RR359 Emma Glass

Client
BSSL Cambsbed 1 Ltd
Project
East Park Energy
Drawing Title

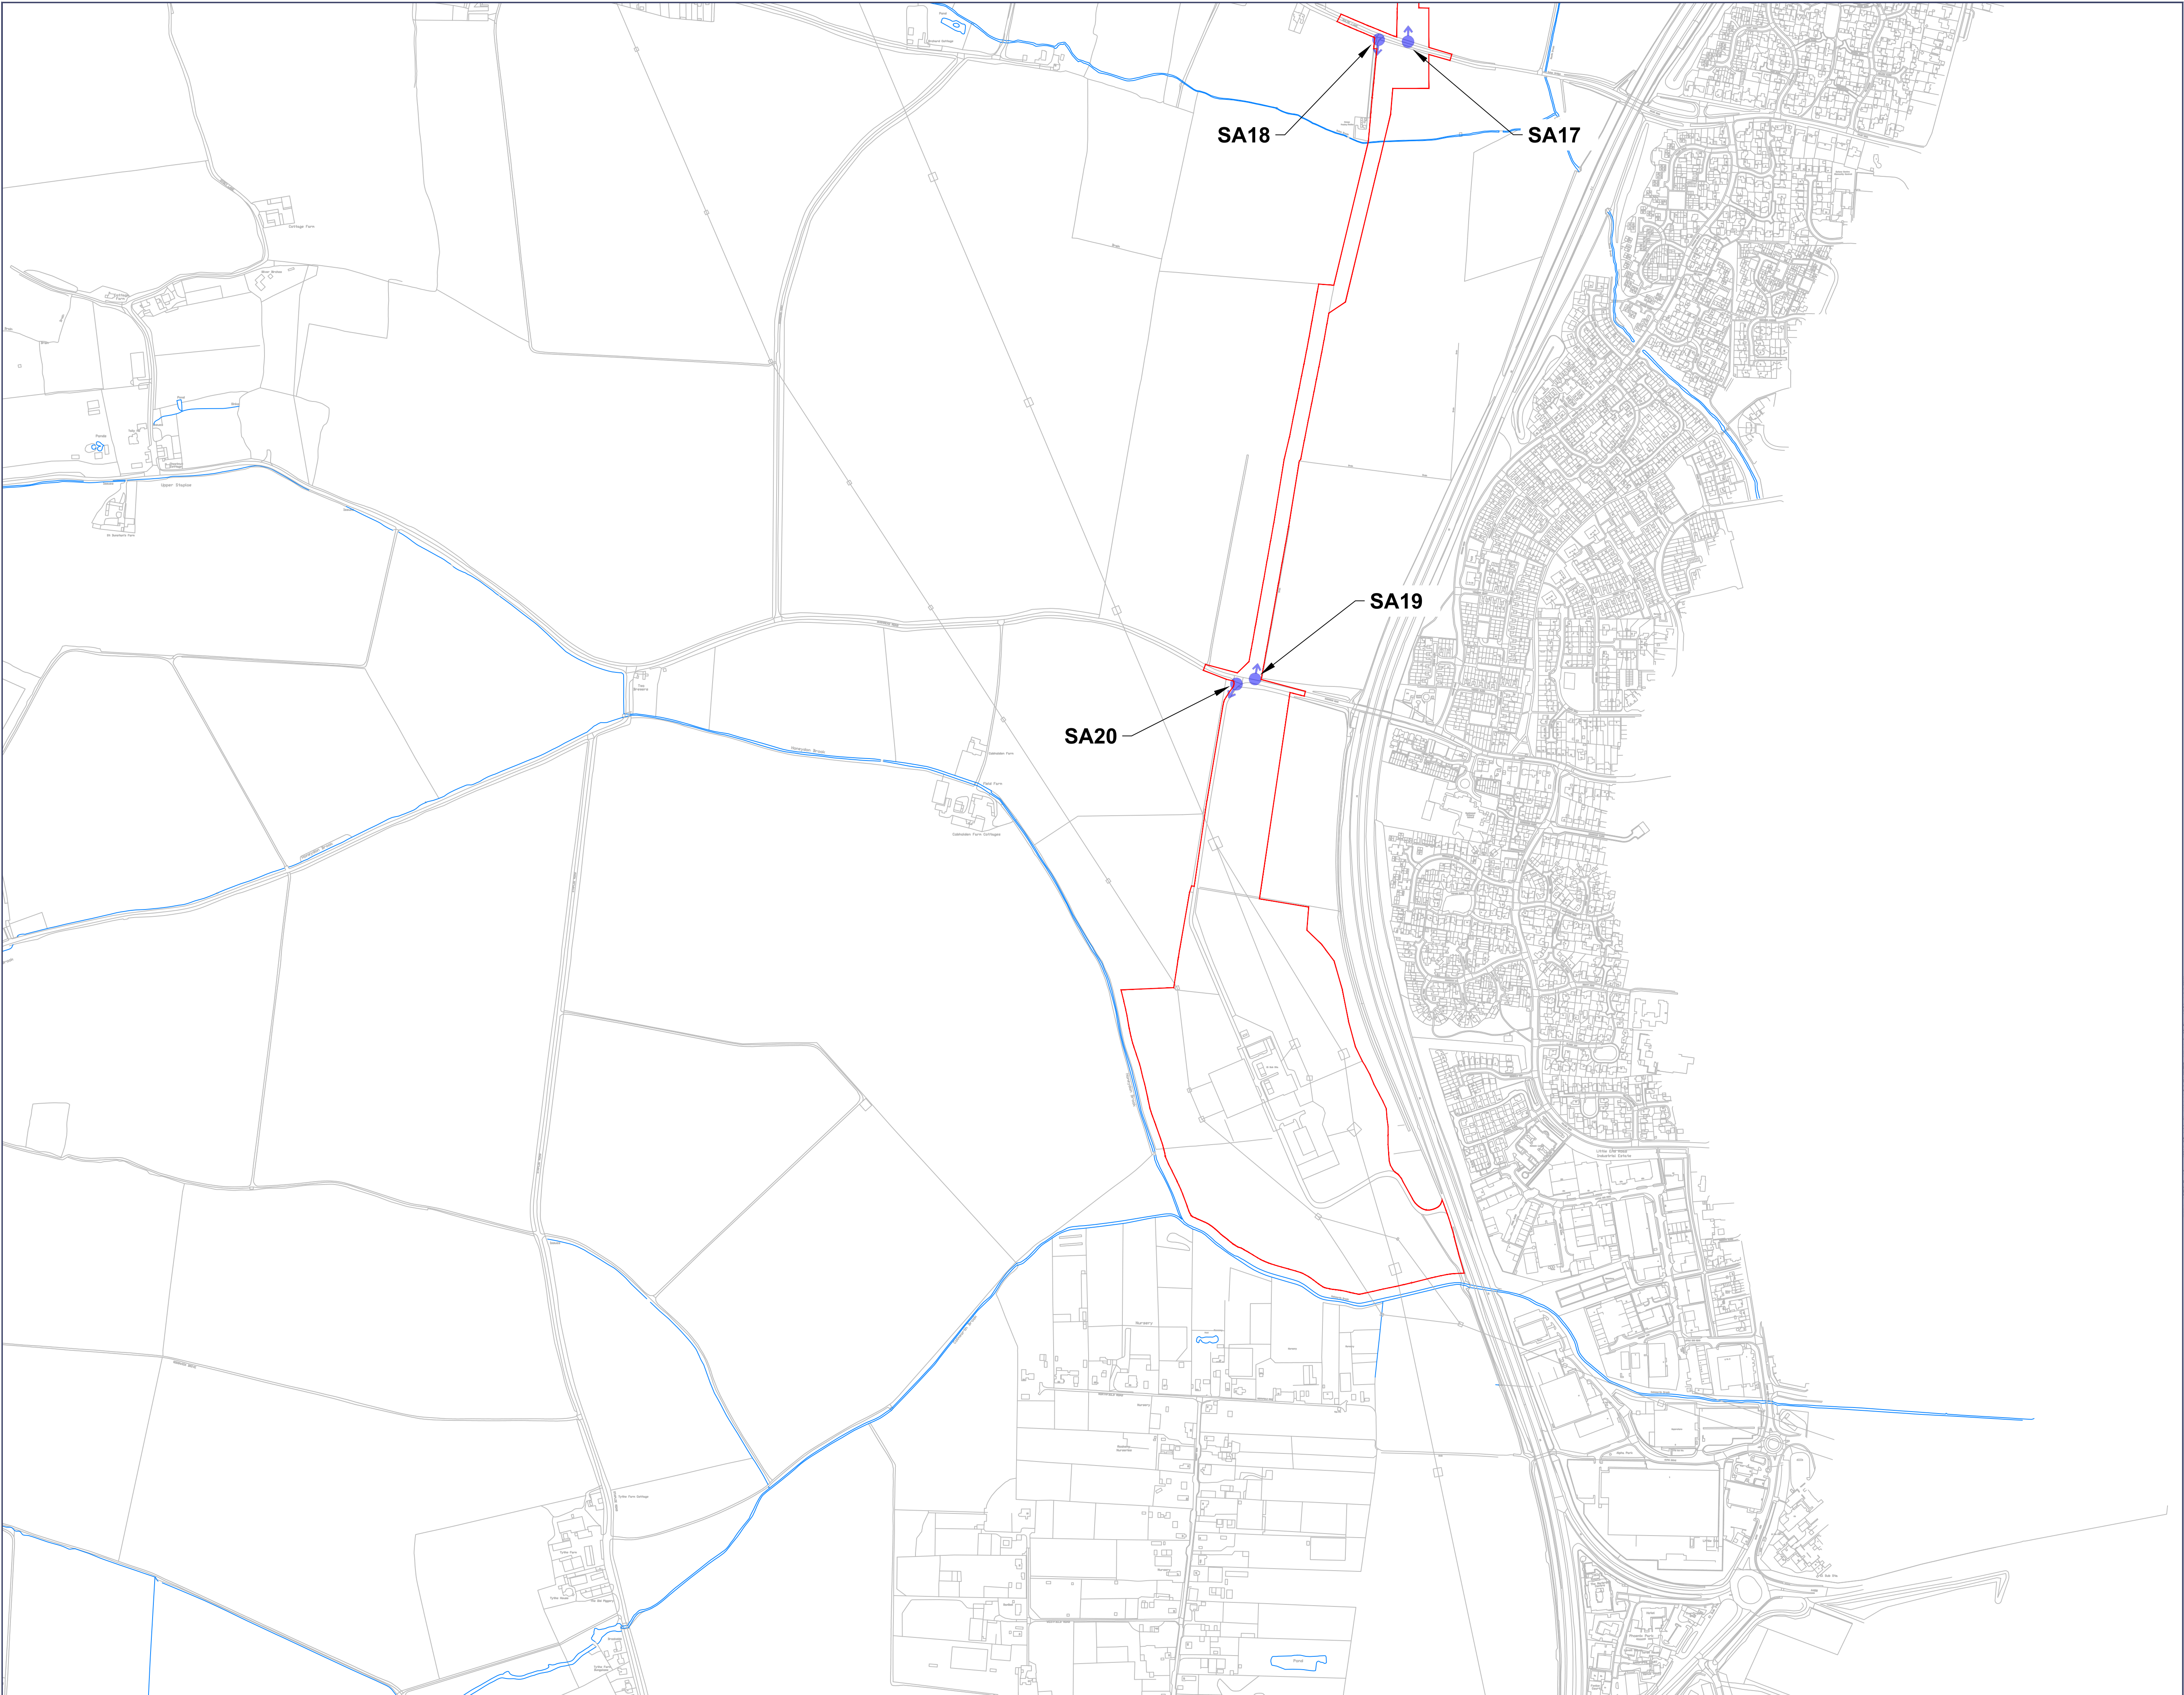
On the original plans, the entrance to Site D compound was through tracks after Hail Weston and before the bends, towards R A Hamilton Farm. This alternative would significantly reduce risk and allow for controlled access with traffic lights.

Why has this safer access route not been pursued, and will it be reconsidered?
